# PLANNING BOARD REPORT PORTLAND, MAINE

Bank/Office Building with Bank Drive-through, 20 Marginal Way  
Level III Conditional Use and (Level II) Site Plan  
Bangor Savings Bank, Applicant  
Project #: 2015-080  
CBL 113 A025001

Submitted to: Portland Planning Board Public Hearing Date: July 14 <sup>th</sup> , 2015	Prepared by: Jean Fraser, Planner Date: July 10 <sup>th</sup> , 2015
--	---

EXTERIOR ELEVATIONS

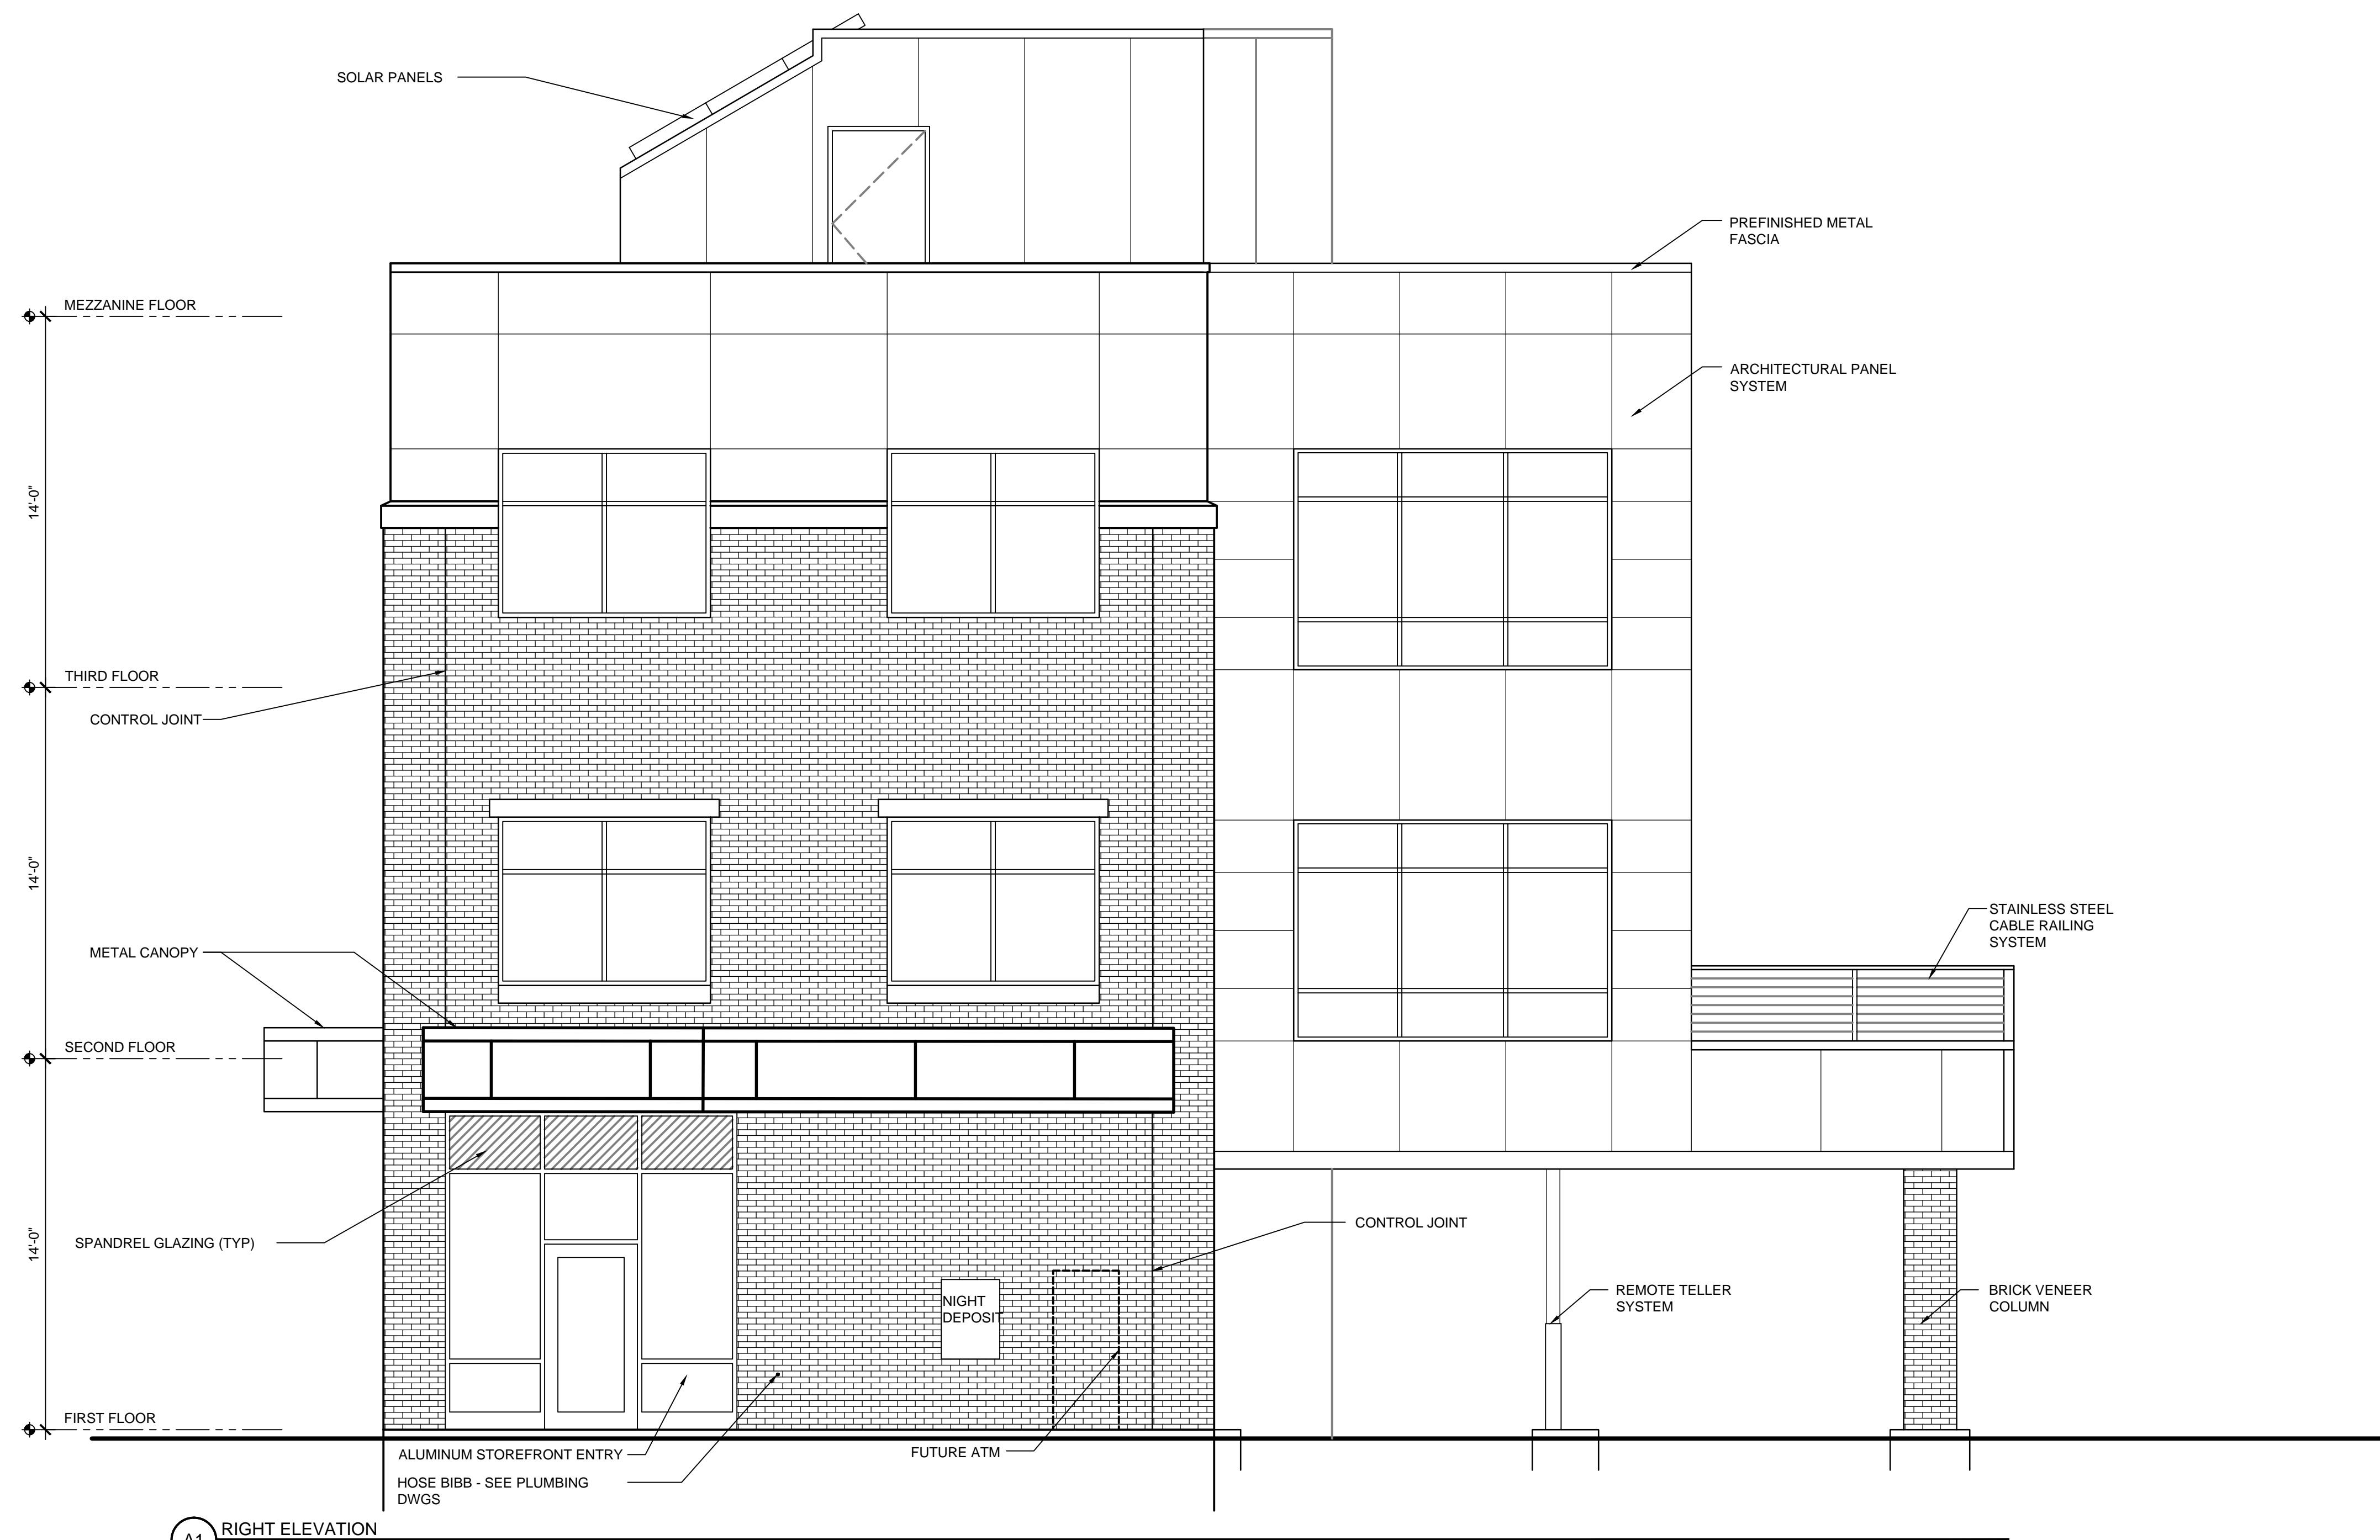
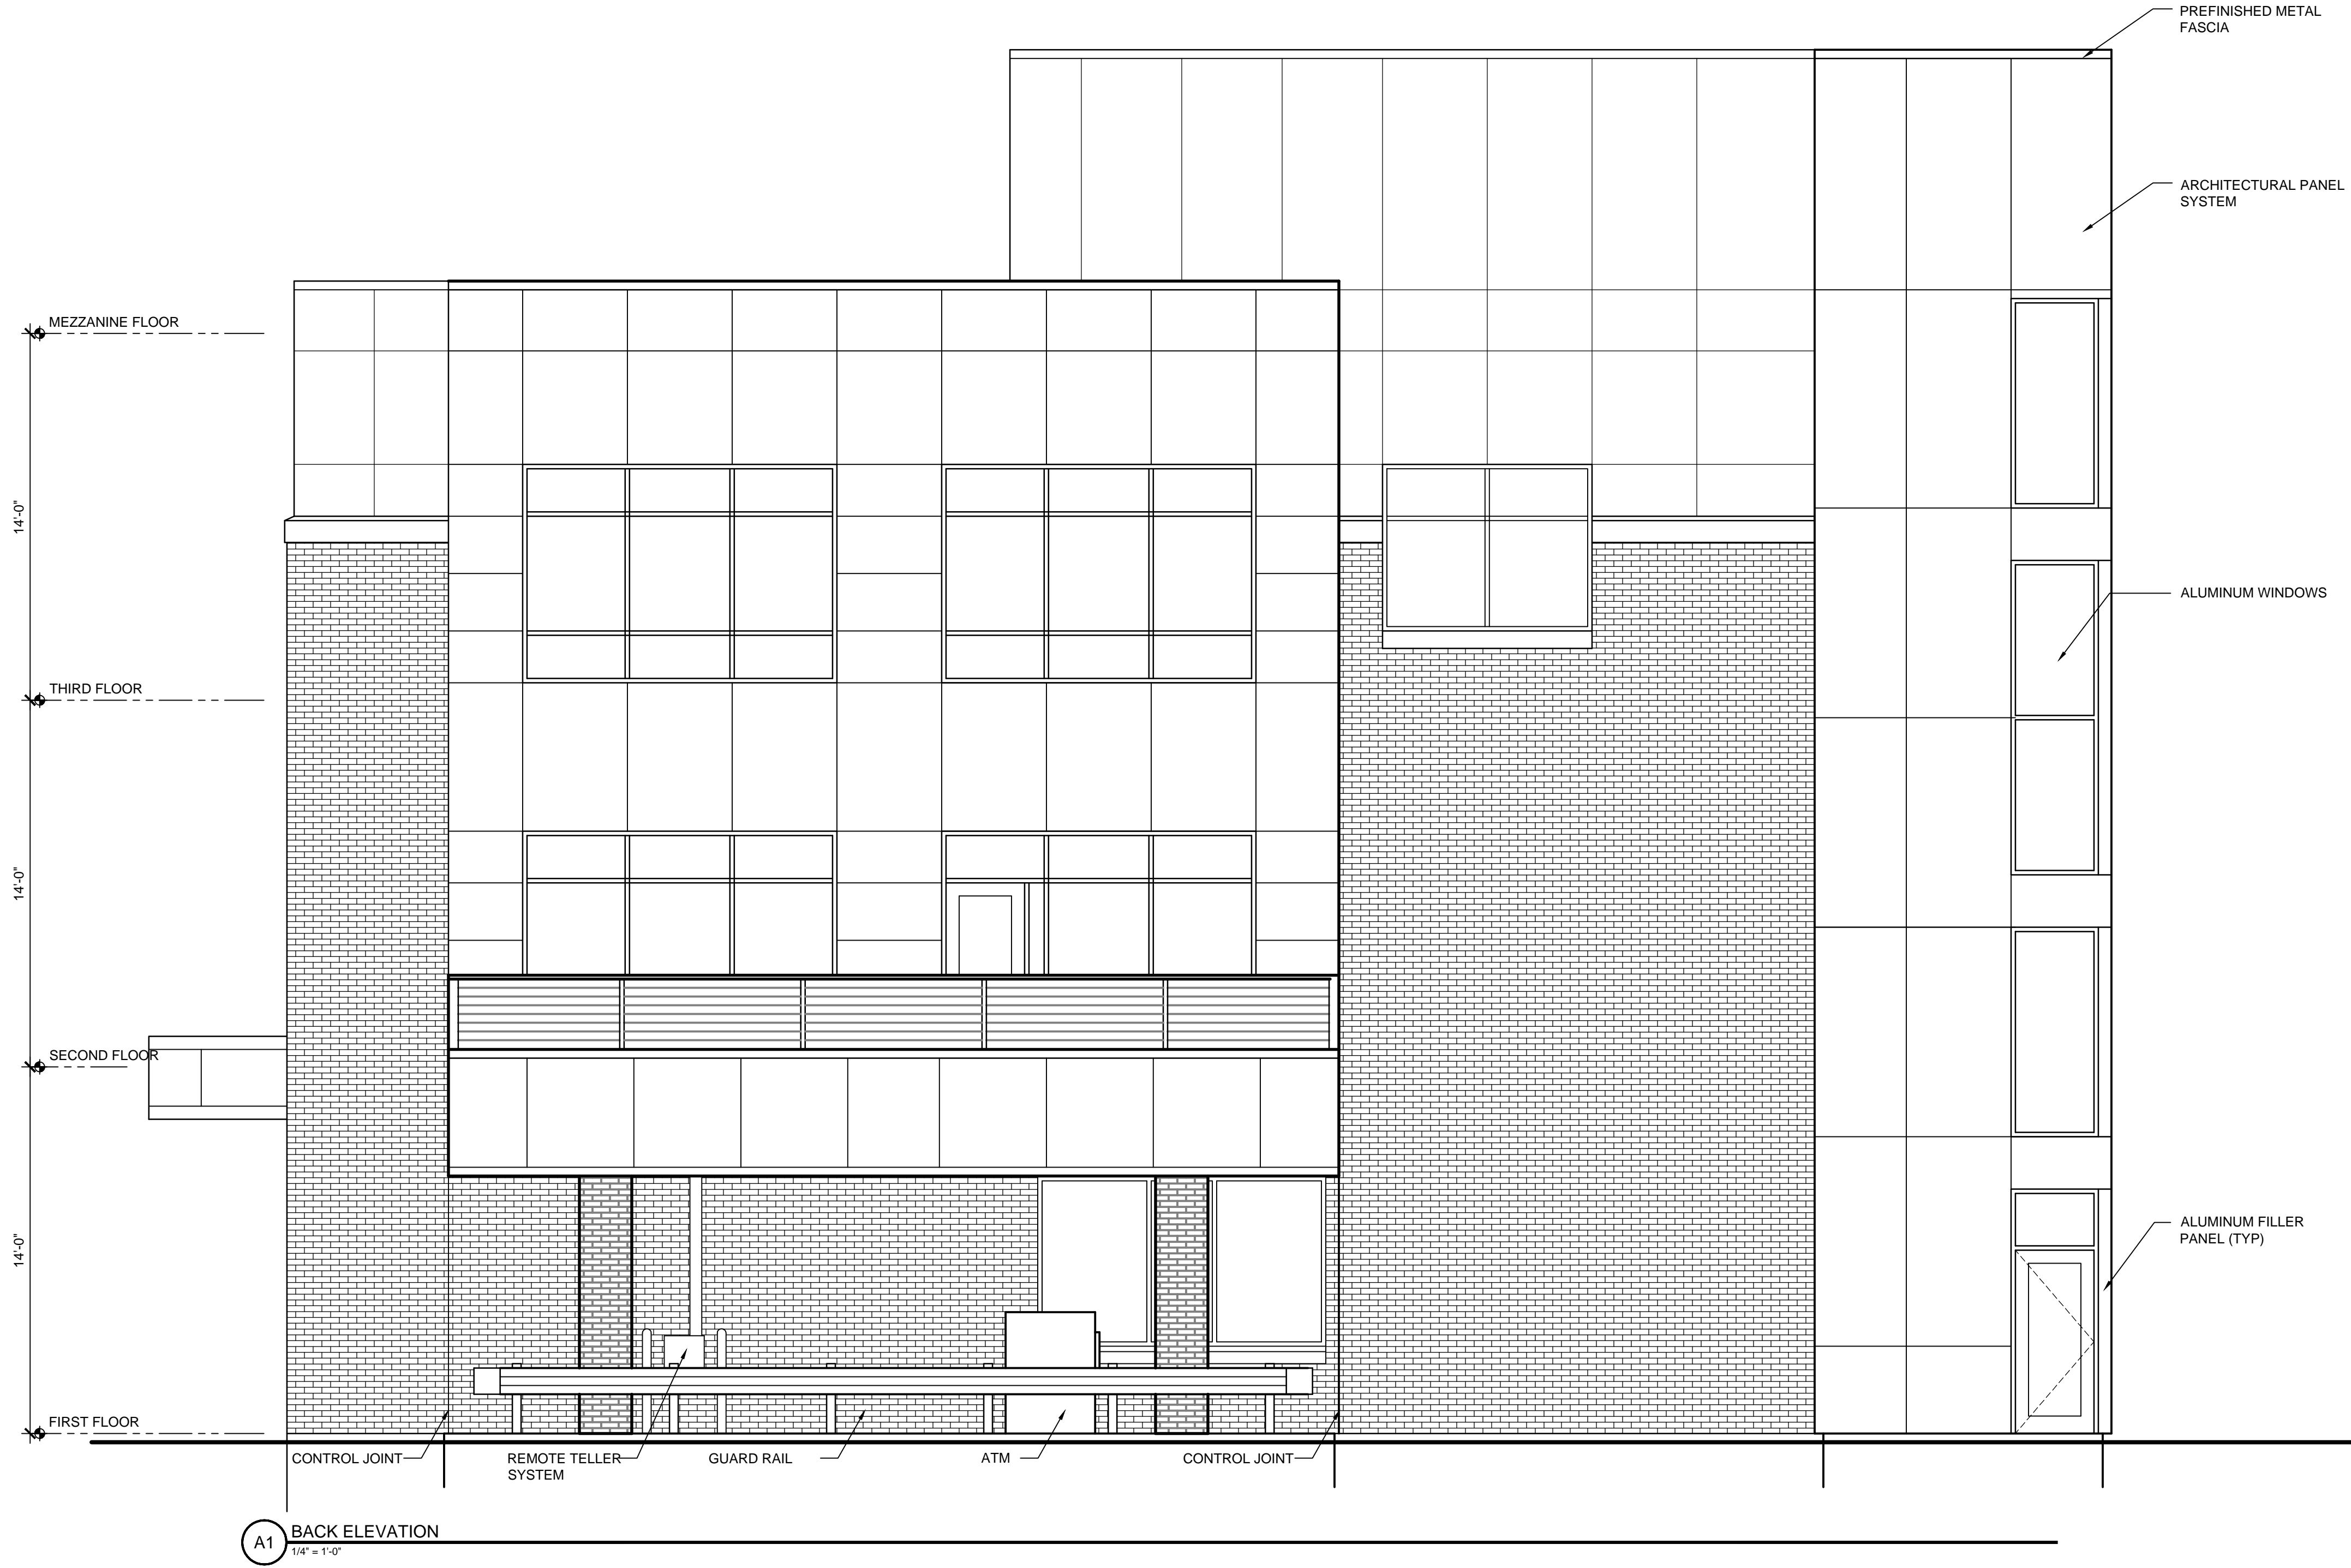
- Building Signage (see submission in Attachment H and Plan P12)
- Transparency and tinting of the glass, particularly along the south facing frontage next to the sidewalk (see submitted info in Attachment I)
- Landscaping to screen parking (see Plan P9 Landscape Plan and discussion above under Site Plan)

Staff recommends a condition of approval that requires the applicant to work with staff to resolve the window design including transparency, color, and size to meet the intent of the B-7 Design Principles and Standards.
